From: Victor Grayson
Sent: 21 February 2025 08:47
To: DC Admin
Subject: FW: Formal Objection to Case Reference 2024/92394.

From:
Sent: 20 February 2025 22:39
To: Victor Grayson <Victor.Grayson@kirklees.gov.uk>; Mathias Franklin <Mathias.Franklin@kirklees.gov.uk>
Subject: Formal Objection to Case Reference 2024/92394.

Dear Mr Grayson, please can this objection statement be included on the case file for 2024/92394. You did advise me previously that you will accept such statements up until 27th February 2025, and I appreciate your co-operation in this respect.

ATTENUATION BASIN DETAILS

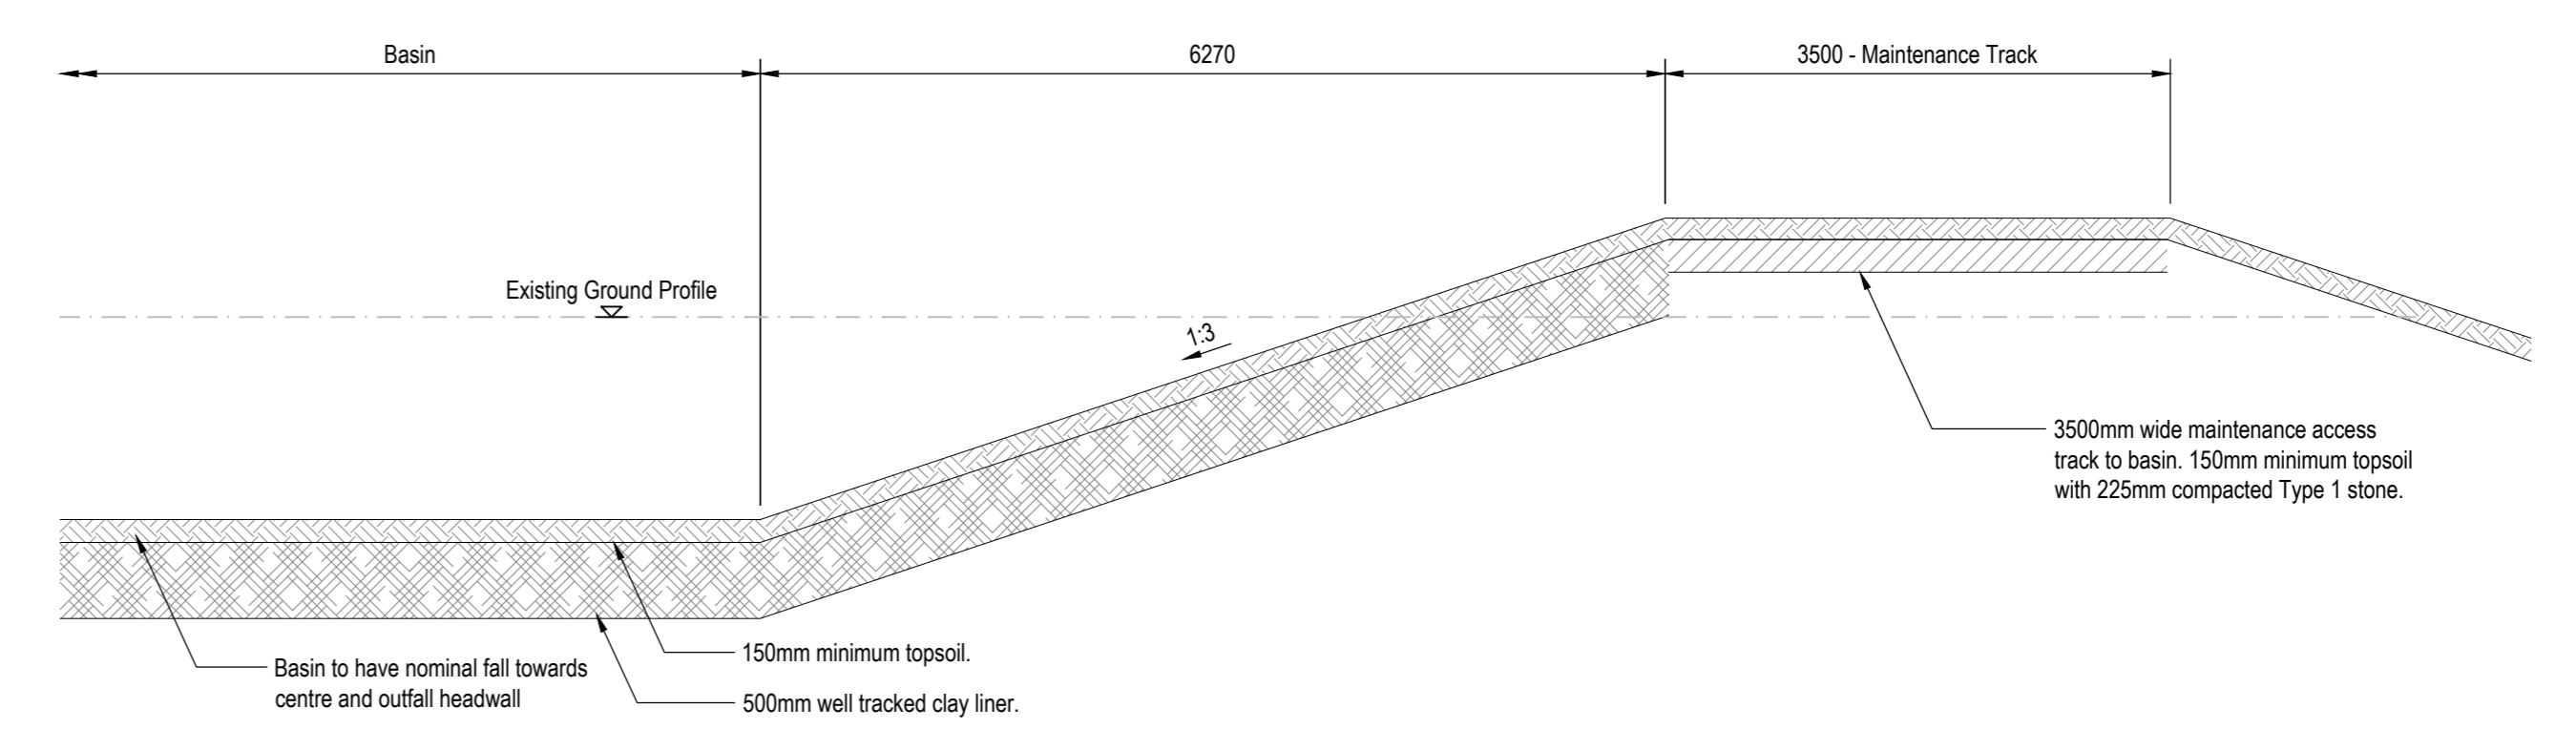
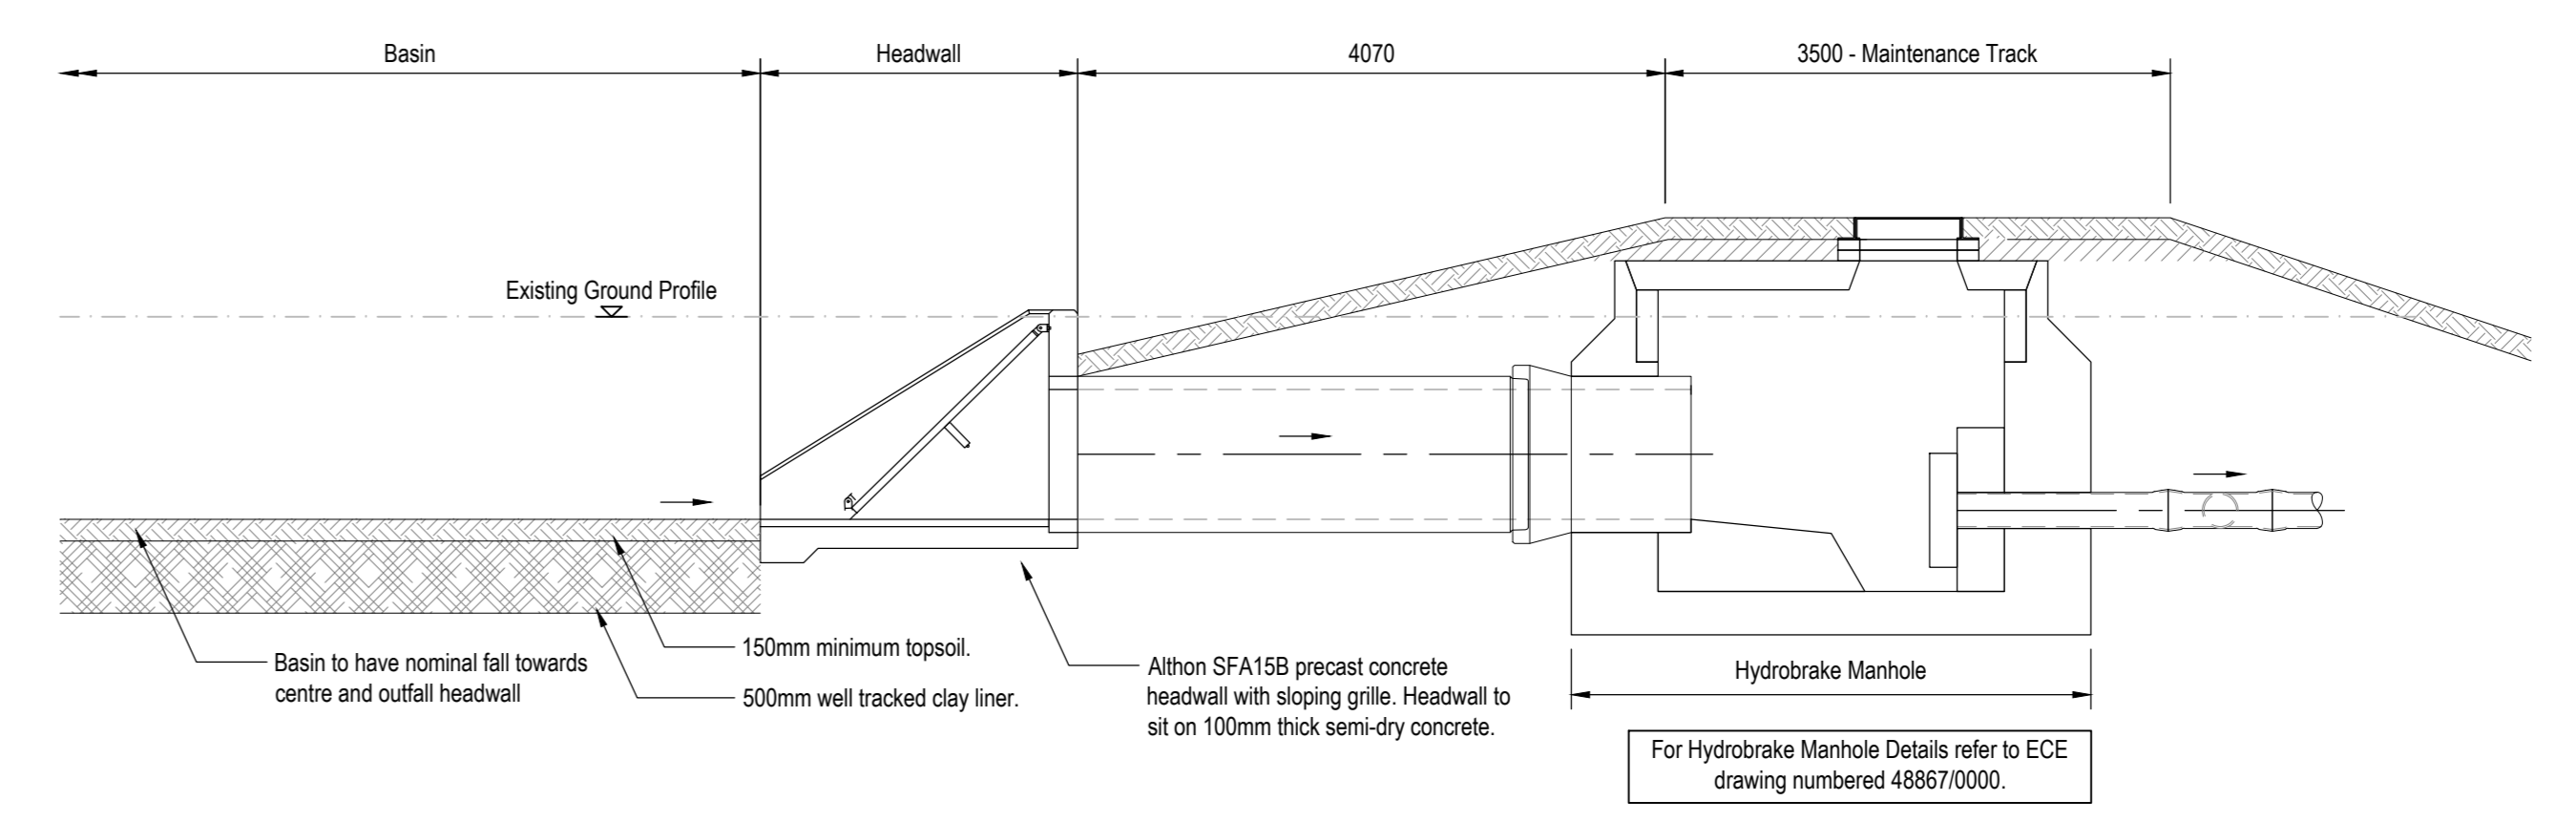
Other residents have submitted objections - now on the case file - and that includes a statement from Councillor Kath Pinnock who has requested that this application should go back to the planning committee. I agree but for different reasons. The depth of the proposed feature 5 feet 5 and a half inches (1.65 metres) does indeed present a safety hazard, given that it is completely open and when containing water poses a risk to children or indeed anyone else, so there is a design issue. However one of my objections in this respect is more fundamental.

The elevation and location of the proposed feature is problematic and would give rise to inundation from Mazebrook (Nan Hall Beck) at periods of peak rainfall. As we know this results in a raised river level, which has caused flooding on Brookfield View and Cliffe Lane over many years. This is the situation that exists now. In short the proposed feature would fail to achieve its stated aim of attenuation of surface water run-off from the proposed development as it would be overwhelmed by a flooding problem that exists now, at periods of peak flow. Let me explain:

The proposed new feature is shown on the design plan at an elevation of between 279 feet and 271 feet 7 inches above sea level (85 metres and 82.73 metres respectively). However Mazebrook (Nan Hall Beck) enters and flows along the bottom of the site at an elevation of 268 feet above sea level at periods of normal flow, that is to say not under flood conditions. At periods of peak and intense rainfall we are looking at a very different scenario, where the river level can easily be up by 8 or 10 feet above normal level. You see my point, hence the flooding. Photographic evidence of this can be provided to the committee.

I would like to add that given the depth of the 'Water Attenuation Feature' which is over 5 feet deep, at least 2 feet of that are below the river level of Nan Hall Beck at periods of normal flow, what consideration has been given to aquifer flooding, that is to say subterranean flooding from below. We know that the three abandoned mine entrances only a matter of yards behind proposed location have had to be periodically pumped out to prevent this, and we also know that there are eleven abandoned mine workings around or near the site (not all of them for coal) and that there has been aquifer flooding in the past.

Additionally the amount of surface water runoff from non permeable surfaces on that side of the site into the 'Water Attenuation Feature' has to be accurately assessed in terms of the proposed discharge into Nan Hall Beck. We know that there should be a discharge rate of 17.5 Litres per second into Nan Hall Beck from this feature but that is only 3.850 Gallons (30.795694 Pints) per second; at periods of high rainfall we would have a hard surface area of 297,622.00 square feet discharging into it out of a developed area on that side of the site of 470,050 square feet. Not only would the inflow far exceed the outflow - and this is what must be accurately assessed - but if the 'Water Attenuation Feature' is already inundated by river water en route to flood Brookfield View, then it would merely contribute to an existing major flooding problem.
